Ms Rachael Snape
Planning and Development Manager NSW/ACT
Triniti T2 Level 5
39 Delhi Road
North Ryde NSW 2113

26/09/2019

**Marulan South Limestone Mine Continued Operations Project (SSD-7009)
Request for Additional Information**

Figure 1
Mining leases, BSAL and gas pipeline

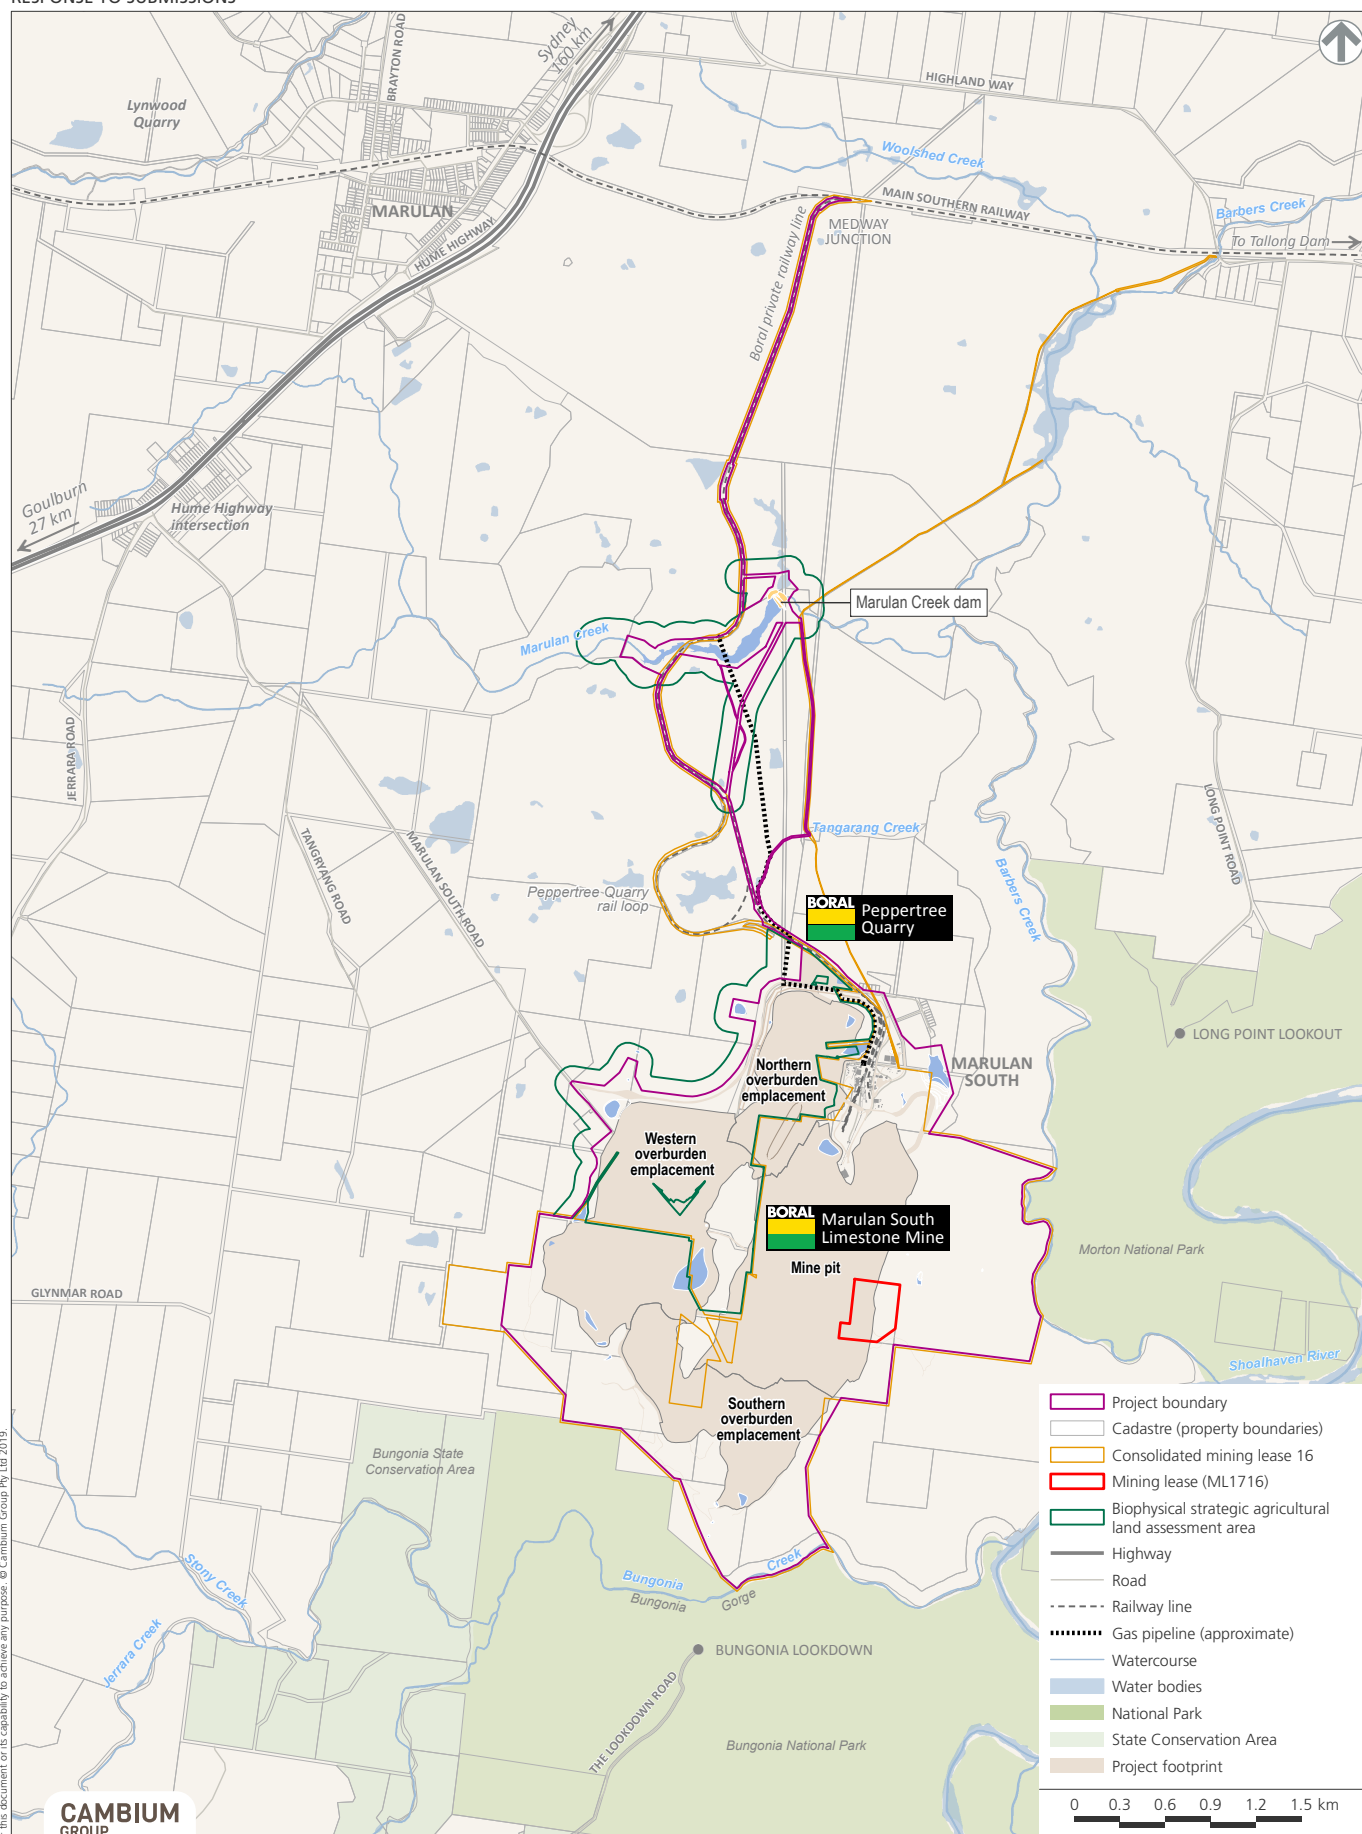
2. Section 19.3.5 of the EIS indicates that blasting impacts would not exceed the structural damage criterion "at all non-mine-owned infrastructure, including the Jemena gas pipeline that supplies the mine with gas." This pipeline does not appear to be identified in the supporting figures within the EIS. The Department requests that the location of this pipeline is made clear and seeks confirmation regarding the status of Boral's consultation with Jemena.

7. Please provide a high-resolution figure which overlays the:
 - project layout;
 - current mining lease boundaries; and
 - the Biophysical Strategic Agricultural Land assessment areas associated with the 2015 Site Verification Certificate.
